City of Sydney Review Response- Waterloo Metro Quarter

It is understood that after submission of the planning documents for the Waterloo Metro Quarter Development, commentary has been provided on the submission. The comments received are noted below, with commentary in response discussed in this letter. This document is an addendum to the submitted Appendix JJ – Central Precinct Landscape Design Report.

Deep Soil

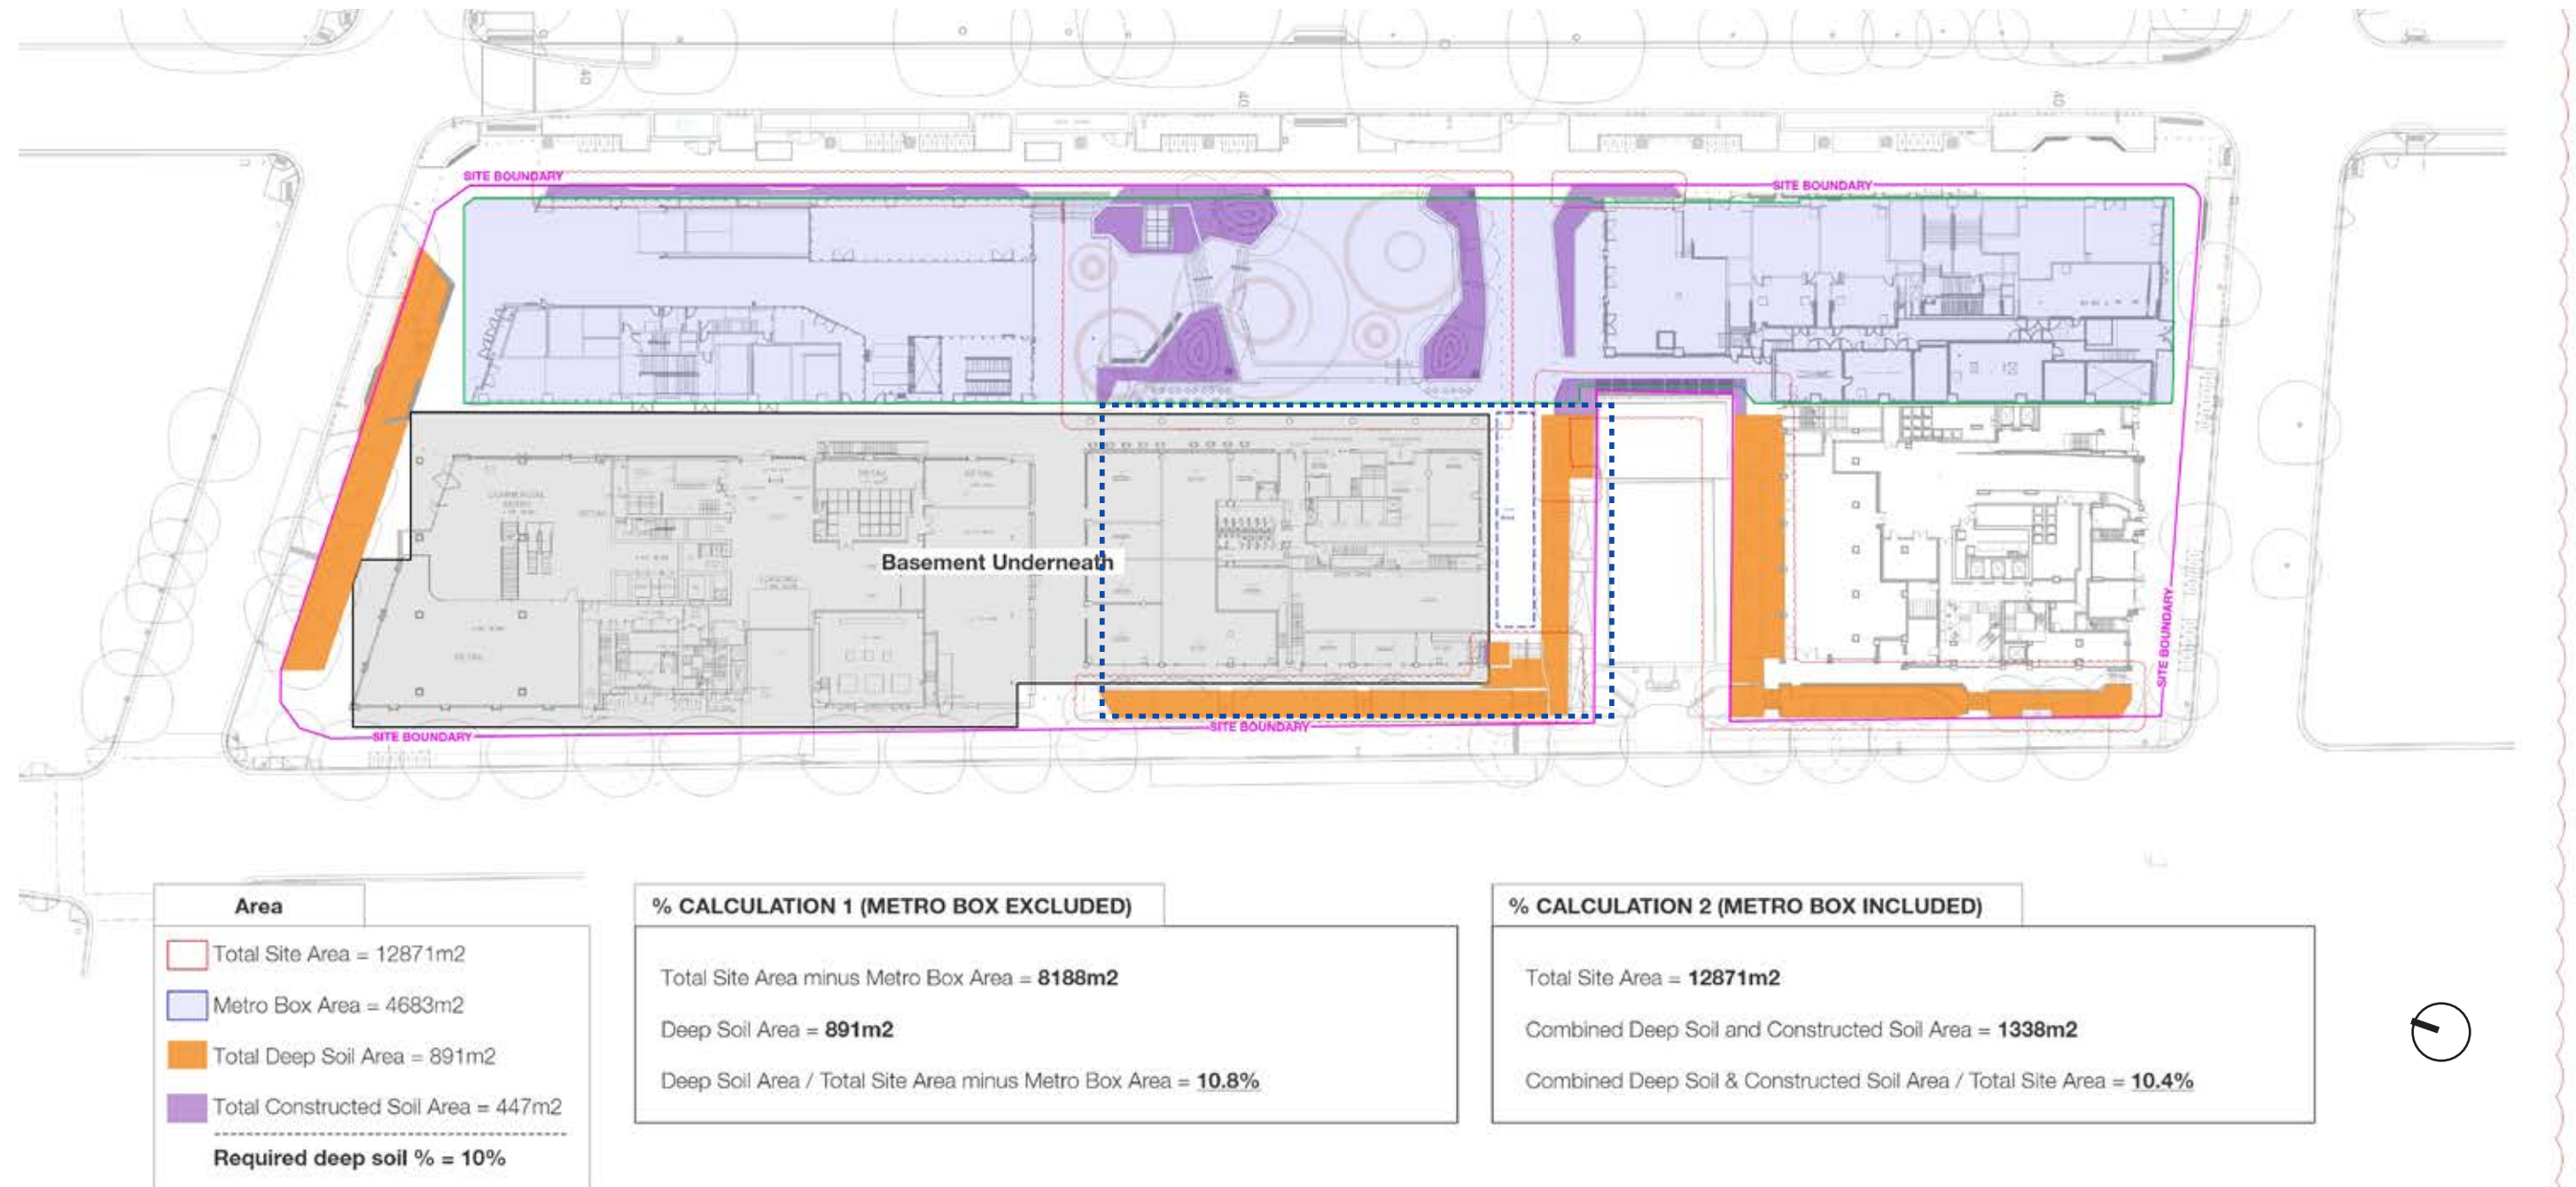
Landscaping (continued)		
38	<p><i>Deep soil – Deep soil is underprovided, equating to approximately half of the area claimed. The Sydney Development Control Plan 2012 (SDCP) and ADG both have a minimum deep soil dimension of three metres. Many of the proposed garden beds are less than this three metre minimum and it is noteworthy that the remaining quantity of compliant deep soil relies heavily on permeable paving. City staff calculate that approximately 470sqm or 5.7% of the site area is allocated to deep soil.</i></p>	<p>Deep soil areas have been amended and the calculations now only include soil areas with a minimum width of 3m. This includes a 3m wide deep soil area to the Botany Road frontage, removing raised planter retaining walls and providing a continuous planting area with steps bridging this space and permeable surfacing to the cantilevered ramp. The deep soil area allocated to the site now measures 10.4%.</p> <p>Refer to Central Precinct Landscape Design Report page 15 'Deep Soil'.</p>

LEVEL 22 | LANDSCAPE PLAN

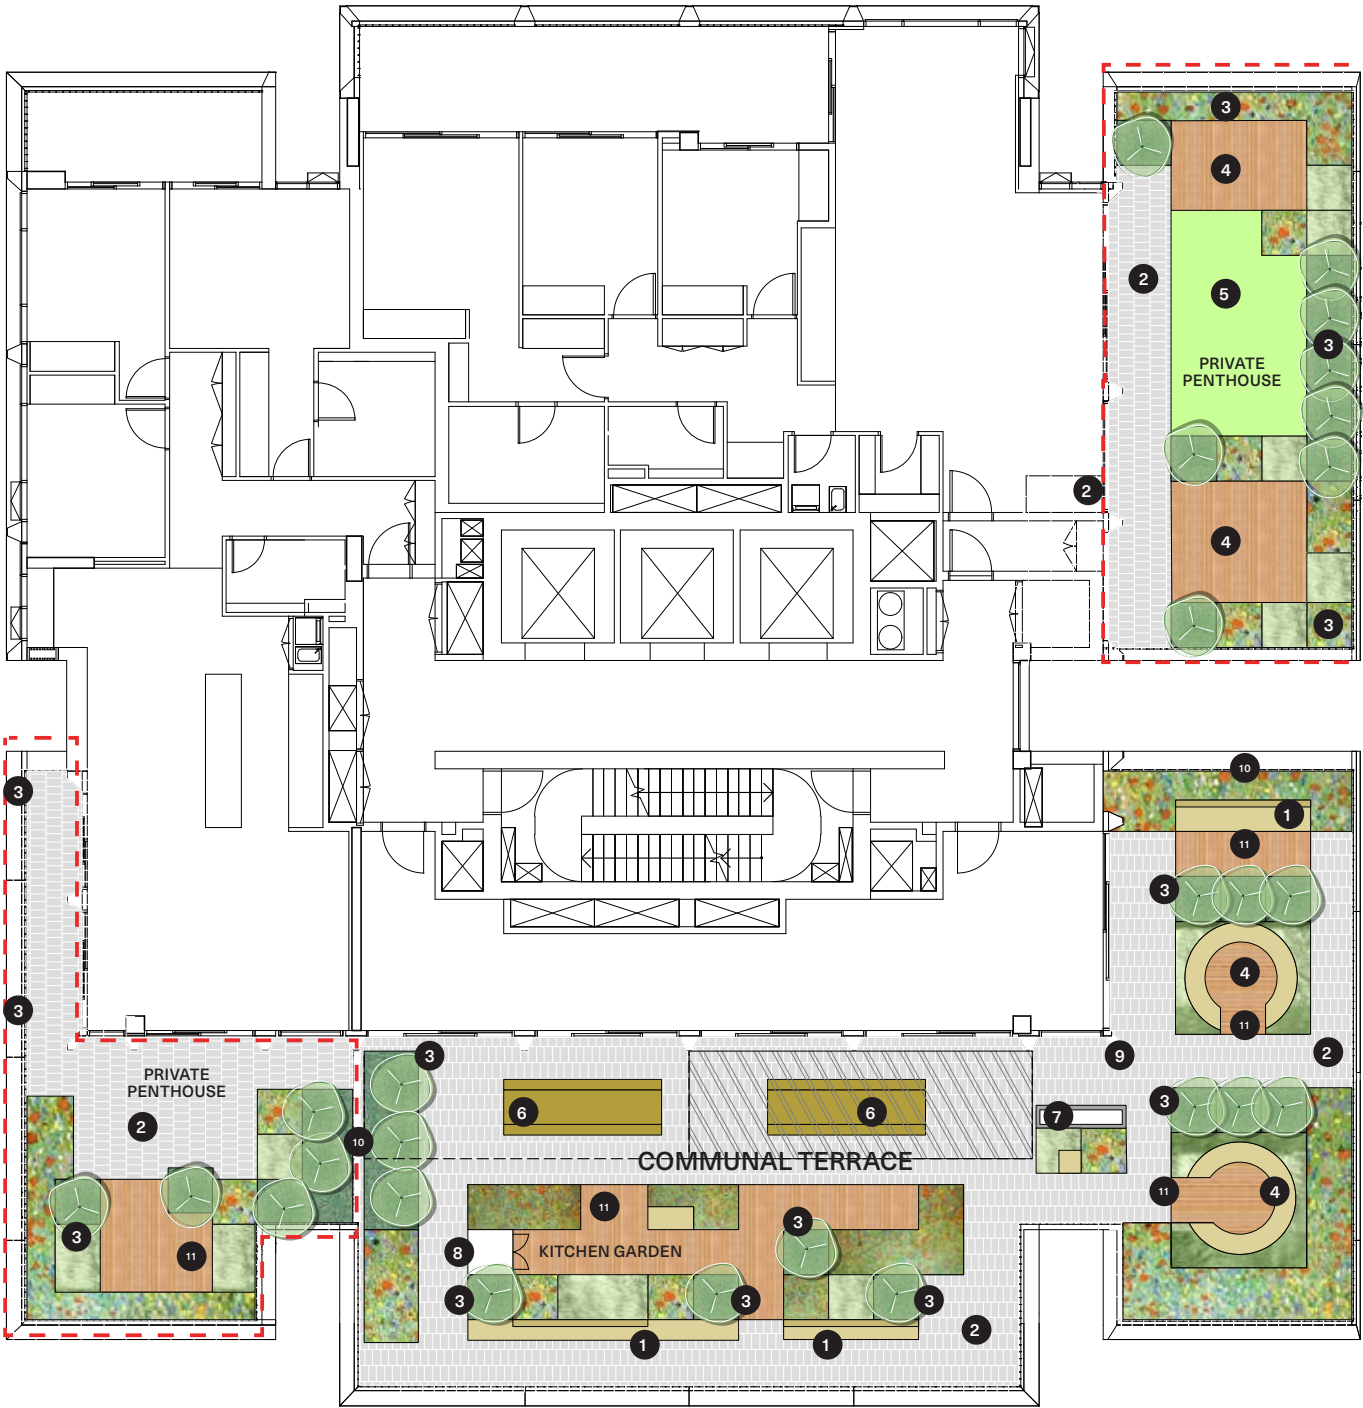
40	<p><i>Green roofs - The maintenance access to all green roofs and planters at height is to be clarified. Wherever possible, planting should be able to be maintained without the use of specialist safety systems. To this end, fence lines should sit on outer edge of planters, not in the middle to ensure all planting is accessible from within the space. Any communal allotment gardens must be supported with necessary facilities such as taps, storage shed for tools, space for compost and so on. They should also be designed to create useable, interesting spaces between, with seating and shade as appropriate.</i></p>	<p>All planters can be maintained safely from the accessible areas of the terraces.</p> <p>Inaccessible green roofs can be safely maintained from maintenance paths around the planters away from the edge of the building.</p> <p>The communal residential terrace to Building 2 provides a series of raised allotment planters spaced 1.2m apart to allow accessible movement and featuring a 300mm timber edge for perching or placing tools on.</p>

DRAWN	CHECKED	SCALE @ A1
HN	SB KL	1:50
DRAWING NO.	REVISION	
WMQ-BLD2-ASP-LS-DRG-DA-300	03

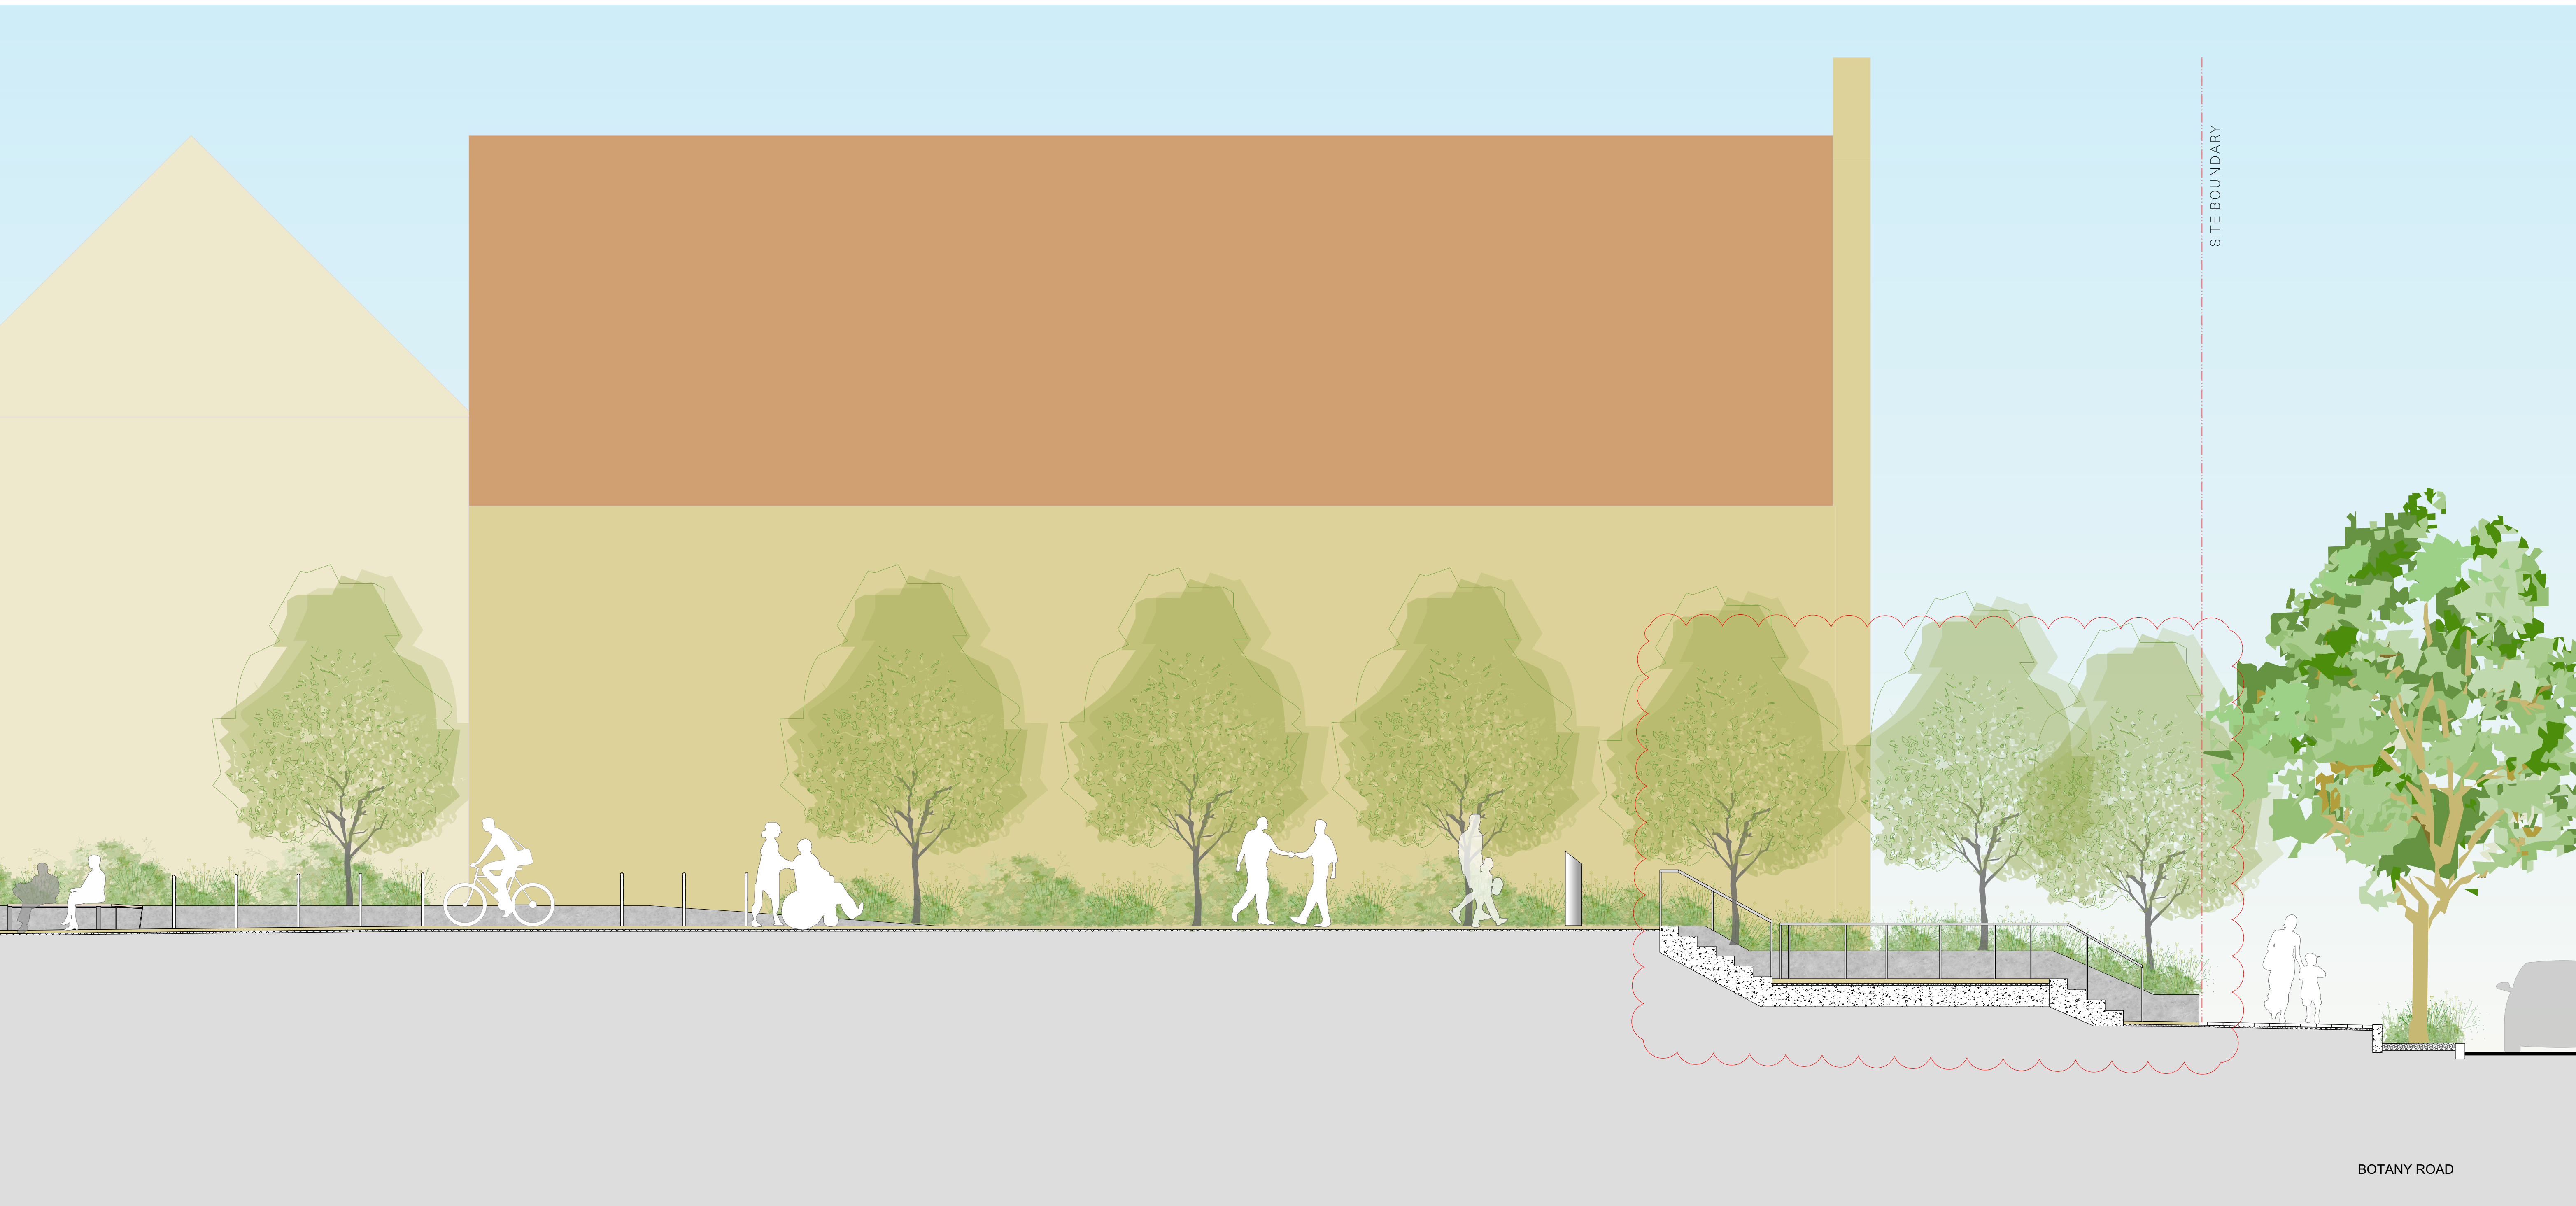
Landscaping		
36	<i>We request that the applicant provides top of wall levels to all walls, and more detailed spot levels across all landscape spaces on all buildings and ground level.</i>	All landscape plans have been updated to include more detailed levels information, providing top of wall and more detailed spot levels. Refer to Landscape Plans. <ul style="list-style-type: none"> • WMQ-BLD2-ASP-LS-DRG-DA-001 • WMQ-BLD2-ASP-LS-DRG-DA-002 • WMQ-BLD2-ASP-LS-DRG-DA-004
37	<i>The applicant is also requested to provide comprehensive landscape sections through all green roofs and accessible landscape terraces, demonstrating soil depth and build-up, as well as the interface with the building.</i>	Sections have been provided for all green roofs and accessible terraces, showing typical soil depths and interfaces with buildings. Refer to Landscape Sections. <ul style="list-style-type: none"> • WMQ-BLD2-ASP-LS-DRG-DA-300 • WMQ-BLD2-ASP-LS-DRG-DA-301 • WMQ-BLD2-ASP-LS-DRG-DA-302 • WMQ-BLD2-ASP-LS-DRG-DA-303
